Response to AGENCY SUBMISSIONS

RESIDENTIAL SUBDIVISION
AT LOT 171 DP 1081810 HIGHVIEW DRIVE, DOLPHIN POINT

Government Agencies Response

REF. No.
24163-21
 SHEET **1** OF 1 SHEETS **06**

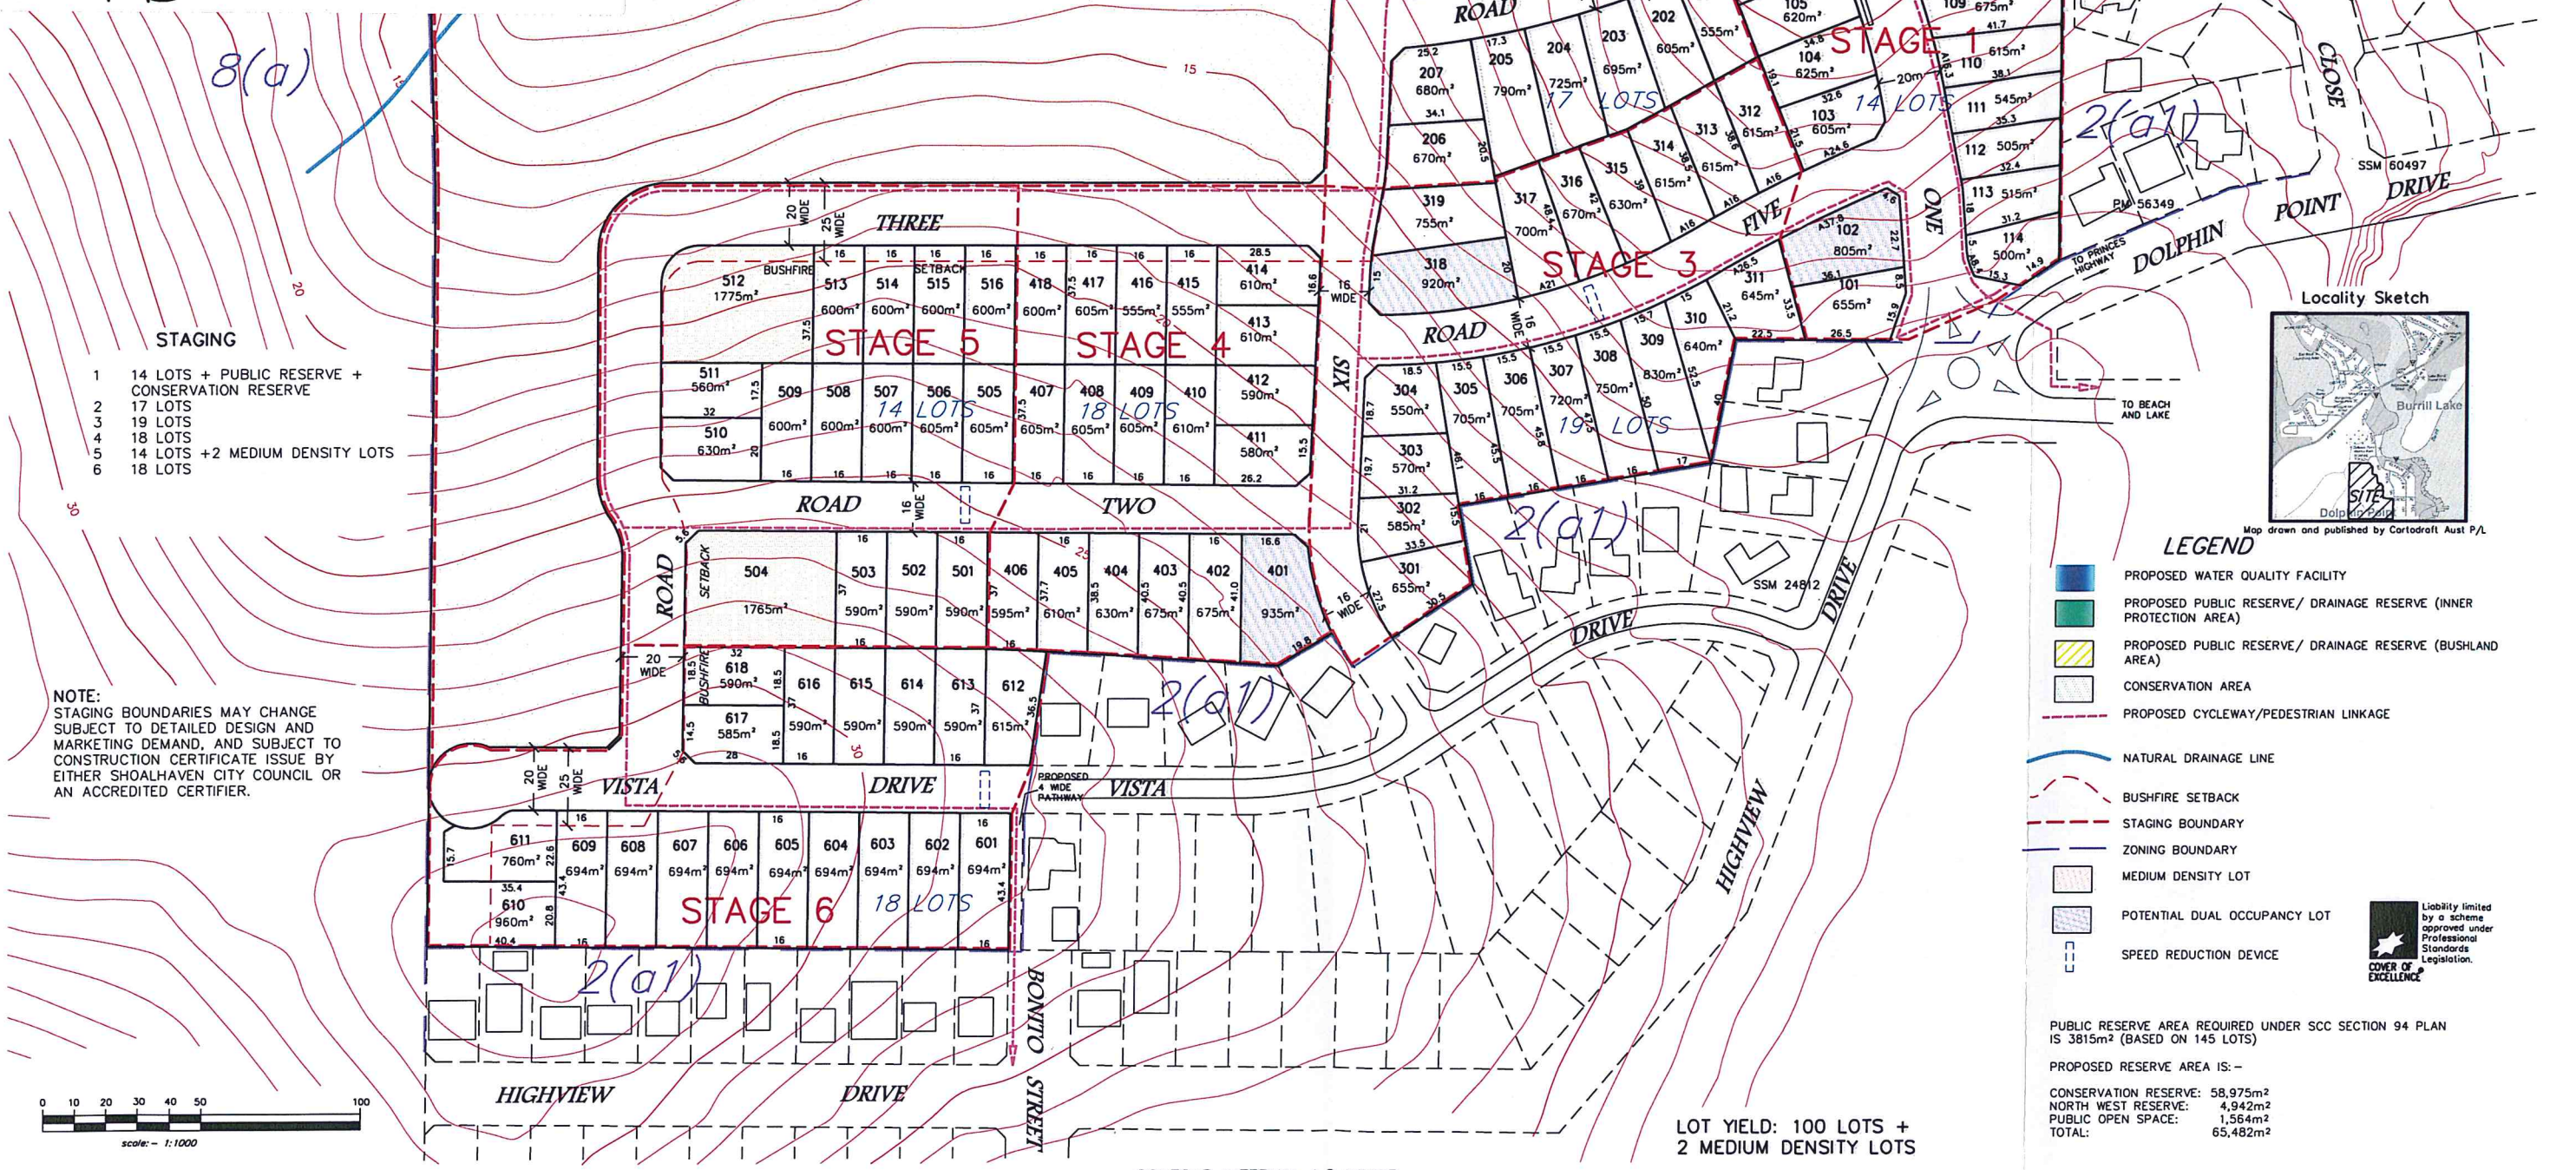
Summary of Issue	APA Response	Amendment
<p>1.0 KEY ISSUES REQUIRING AMENDMENTS</p> <p>1.1 Medium Density Development Shoalhaven Planning Policy No.1</p>	<p>The 2(c) residential zoning is a flexible residential zone that allows for a variety of housing styles, including detached housing, dual occupancies, medium density development, child care facilities, corner stores etc.</p> <p>SPP 1 states that 10% - 20% of subdivided lots to provide for medium density development. Under the 2(c) zone, medium density development is potentially allowable on all lots.</p> <p>Two medium density lots have been provided of the following dimensions:</p> <ul style="list-style-type: none"> • 1530m² • 1620m² <p>Based on Shoalhaven City Council's DCP71 – Medium Density Housing, these sites could support a yield of 13 x 2 bedroom medium density units, which comprises 10% of the standard residential lot yield within the estate.</p> <p>Both proposed medium density lots are corner lots, with good solar access and multiple street frontages, which will facilitate future medium density development.</p> <p>SPP1 does not specifically apply on a site by site basis but applies to the overall Dolphin Point area as a planning policy. The policy is only a guide and the market should dictate the medium density sites. The provision of the amount of medium density housing referred to in the SPP1 in this locality is not seen as desirable given the location of the site which is not adjacent to a neighbourhood shopping precinct. It should also be noted that Dolphin Point Residents expressed concern with excessive higher density development.</p>	<p>Two medium density lots added to proposal. Refer APA drawing 24163-21 Rev 2.</p>

1.4	Road widths	The collector Road No. 1 connecting to the Dairy subdivision has been widened to 20m width road reserve.	Collector Road through site amended to 20m wide reserve width. Refer Subdivision Plan No. 24163-21 Rev 2

1.8	Child's Play Area		<p>Public reserve including children's playground added. Refer Dwg No. 24163-21.</p>

4.2	Remove landscaped median	Landscaped median has been removed	Median removed. Refer Dwg No. 24163-21 Rev 2
4.3	Collector road to have 20m road reserve	Layout has been amended to incorporate 20m road reserve for collector road	Collector Road reserve amended to 20m width. Refer Dwg No. 24163-21 Rev 2

4.9	Design of roundabout at intersection of Road 1 and Road 2 (EA plan)	Roundabout has been removed due to layout amendment	Roundabout removed due to revised layout. Refer Dwg No. 24163-21 Rev 2.

1.3	Solar Access	The subdivision layout has been amended and the number of lots with an alignment of approximately 20E to 30W has been increased to 93 lots out of 130, which is over 71% of the total number of allotments. In the layout submitted with the EA, only 55% of allotments had an east-west alignment. It is our opinion that the number of allotments with the east-west alignment has been maximised, whilst balancing the need for residential amenity and existing street patterns.	Lot layout amended to increase solar passivity of lots. Refer Subdivision Plan 24163-21 Rev 2

Notwithstanding the proponent has agreed to provide additional public reserve area with provision for playground equipment for use as a child's play area in a suitable location shown on the Preferred Project Plan Dwg No. 24163-21.
